August 8, 2023

SUBJECT: Engineering Review Comment  
Mountain View Electric Association Inc. (MVEA)

**Project Name: Saddlehorn Ranch Filing 4 – Final Plat**

**Project Number: SF236**

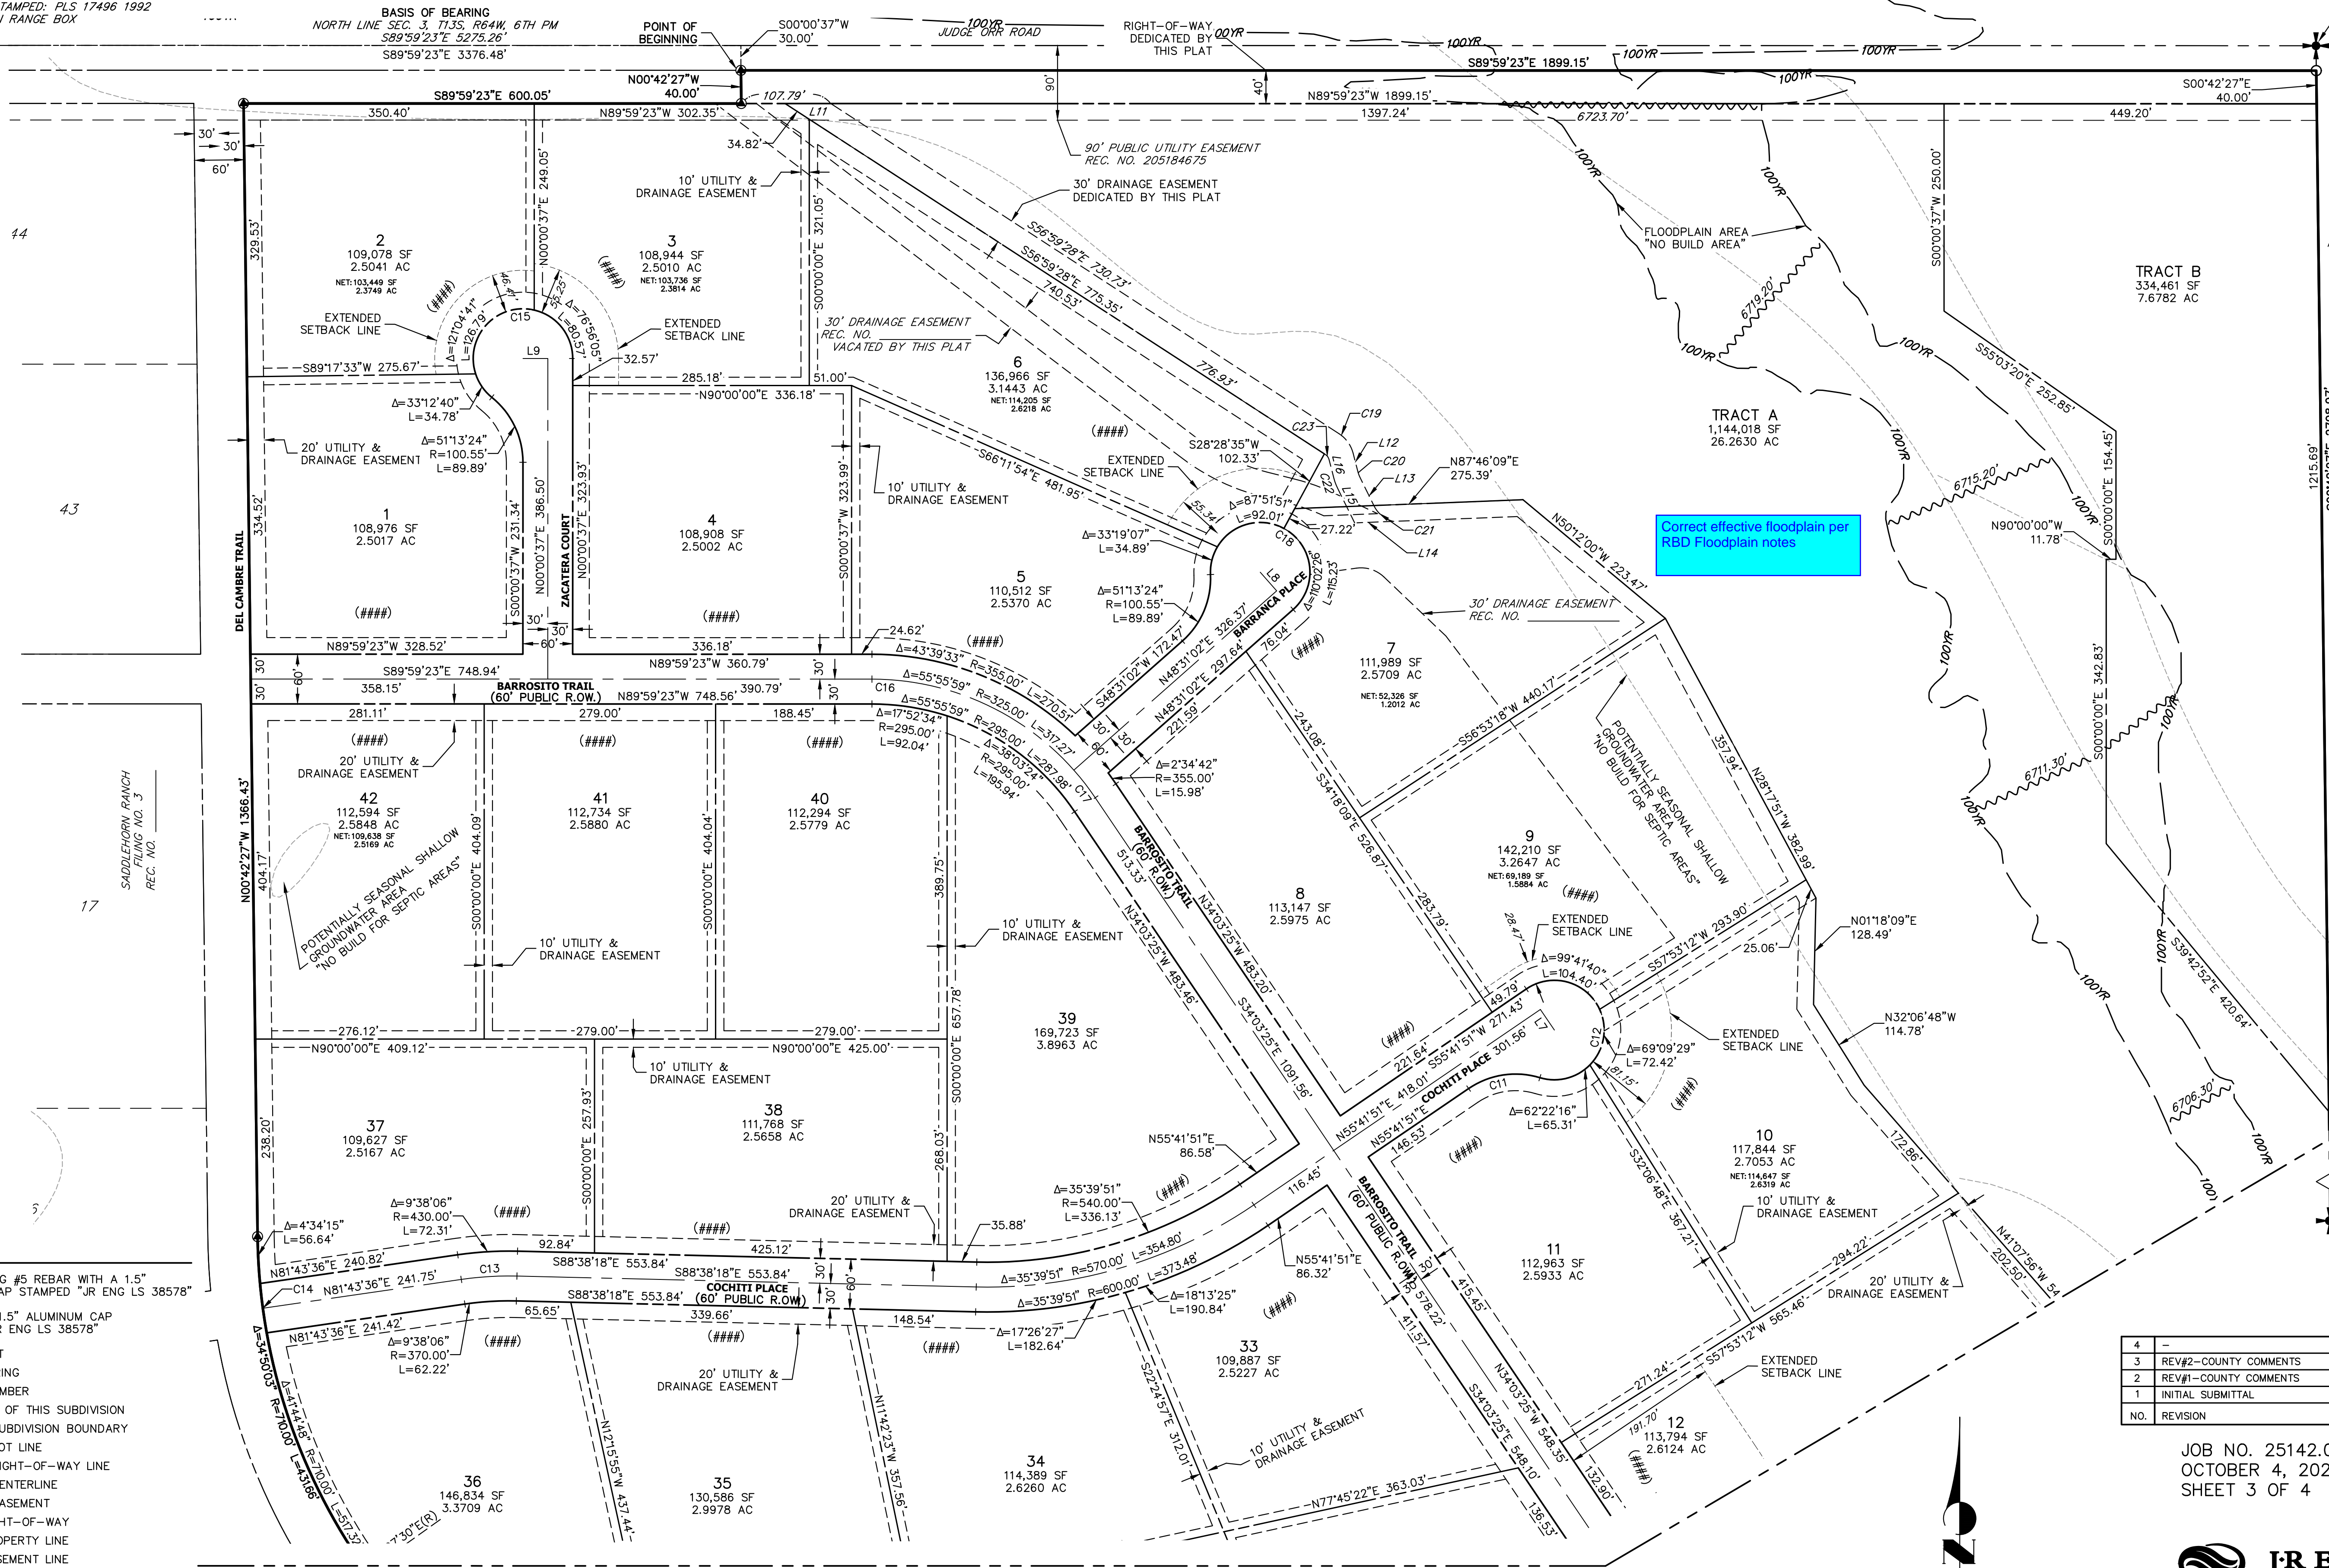
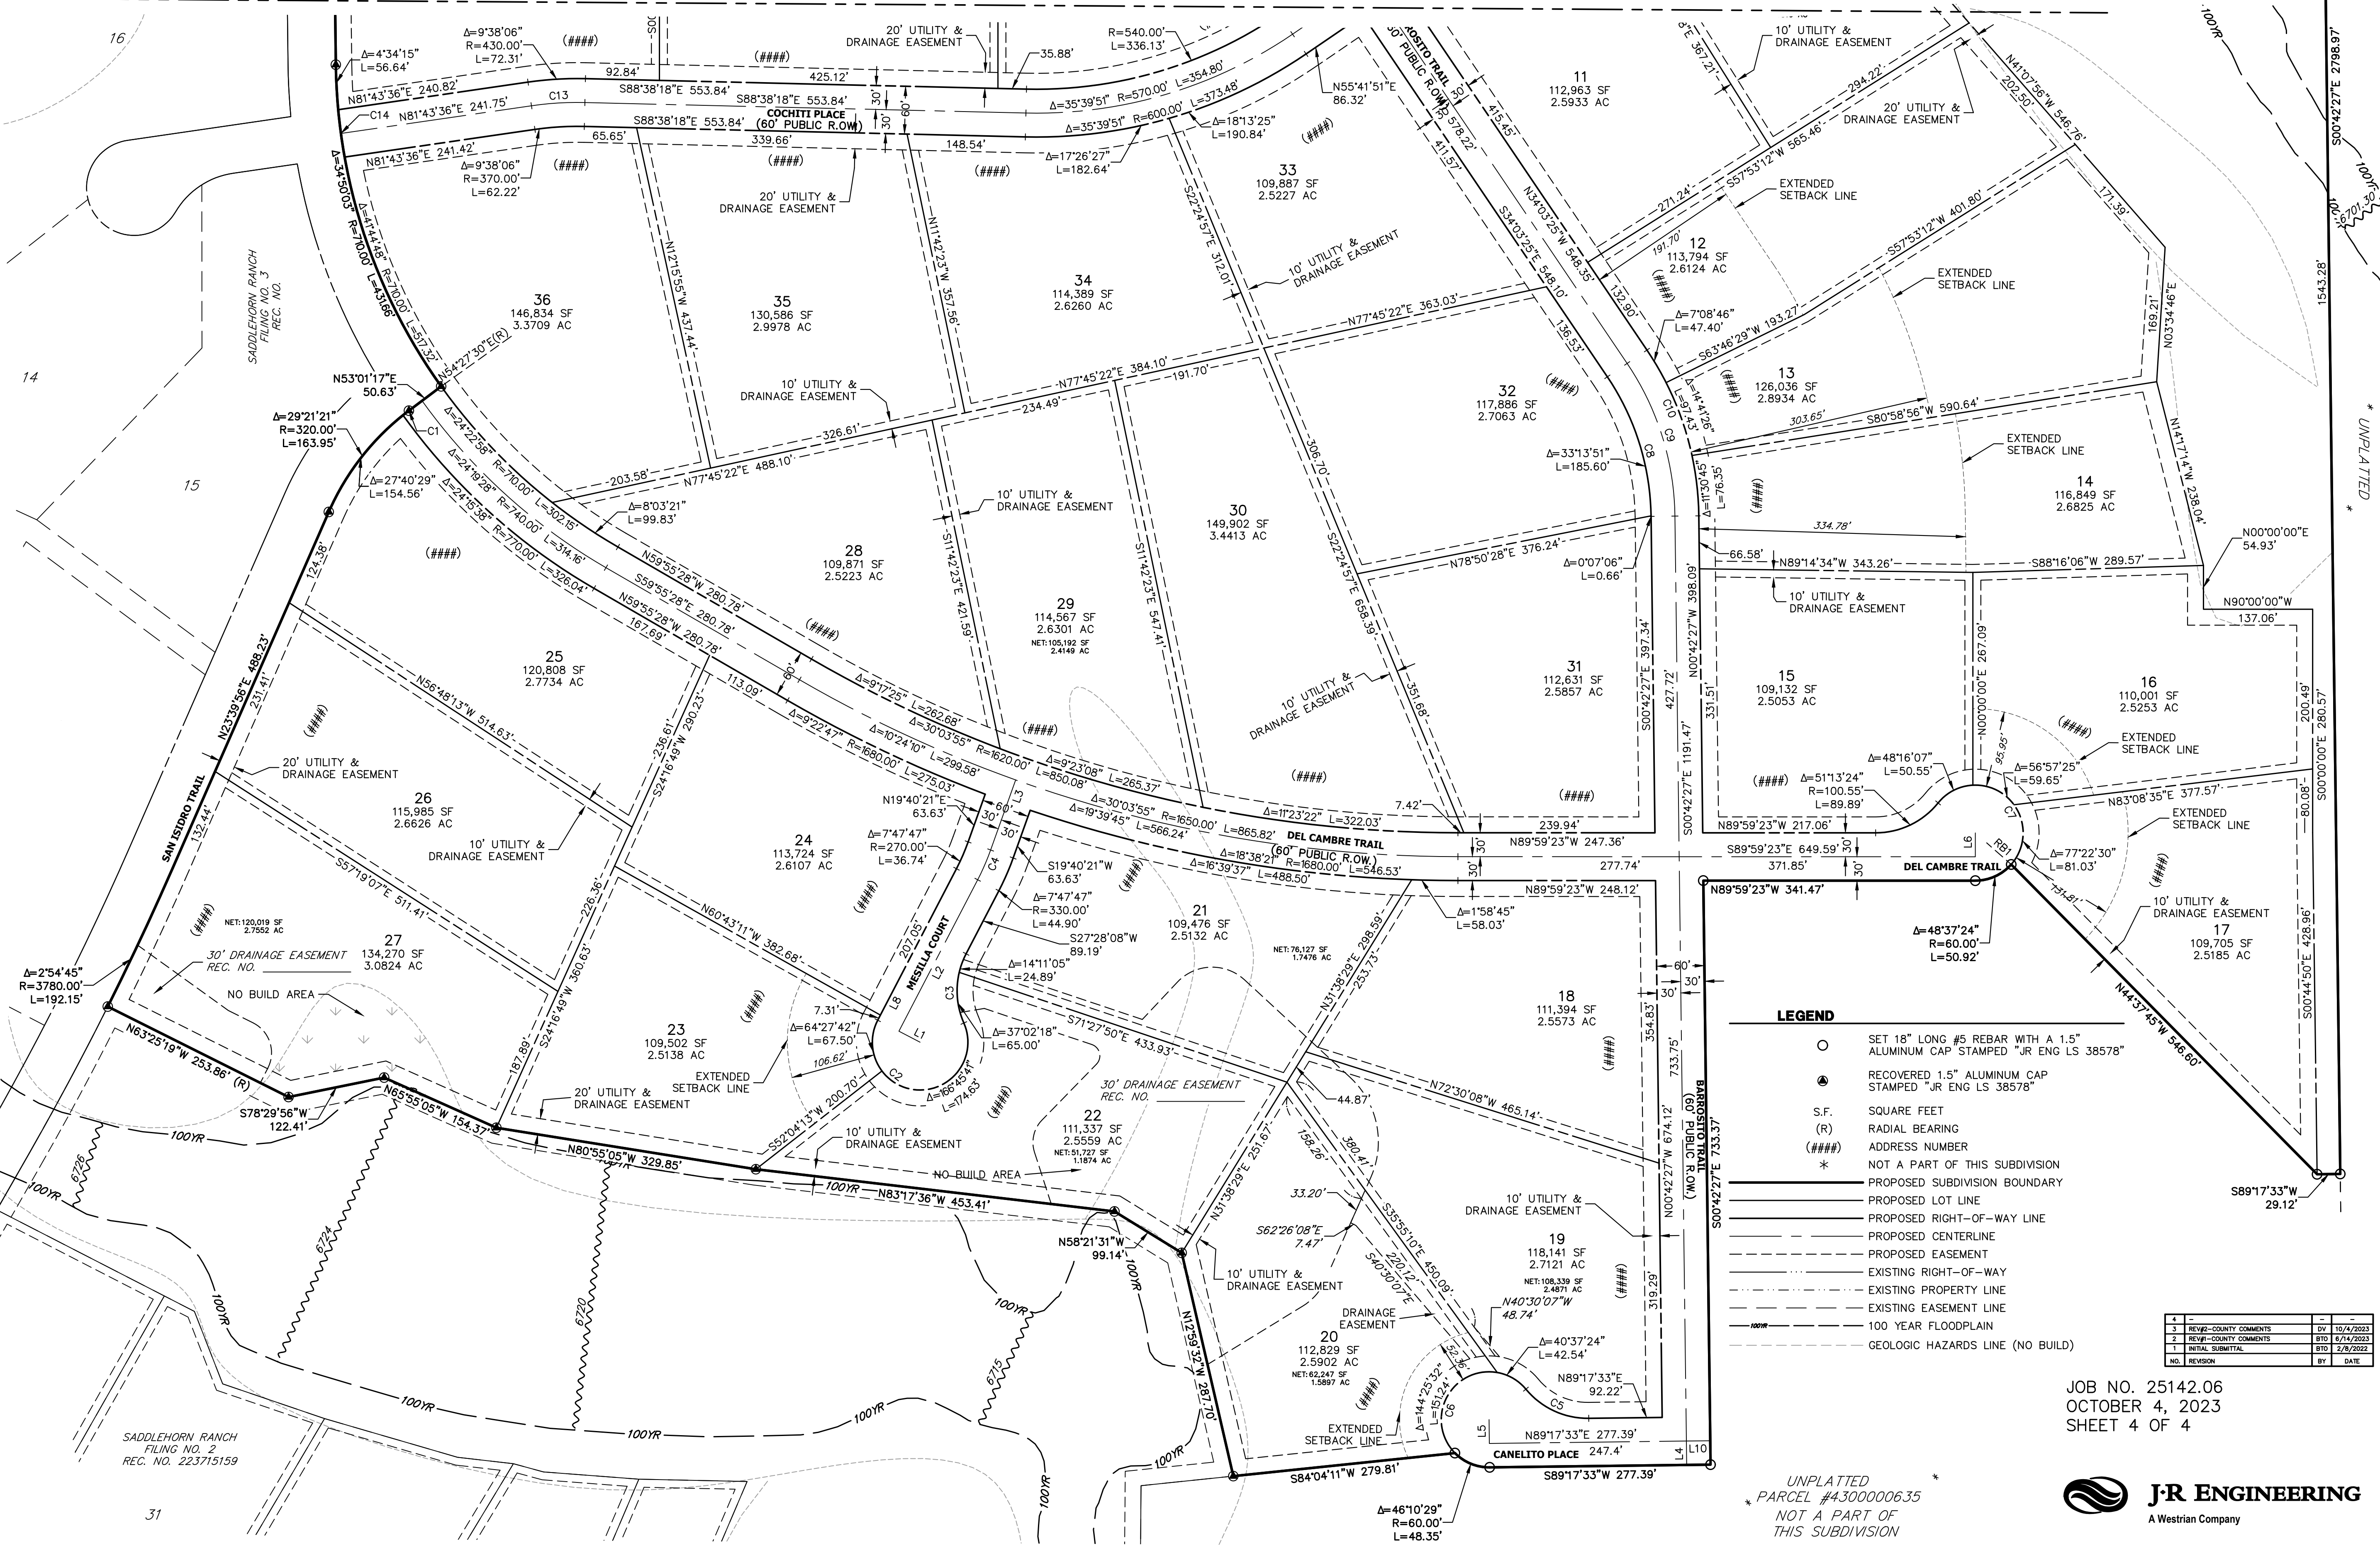
MVEA requests a 40' easement on all front lot lines and any side lot lines along roadways, along with a 10' easement either side of all shared side lot lines. All tracts must be a platted public utility easement along with a twenty (20) foot exterior utility easement on the plat.
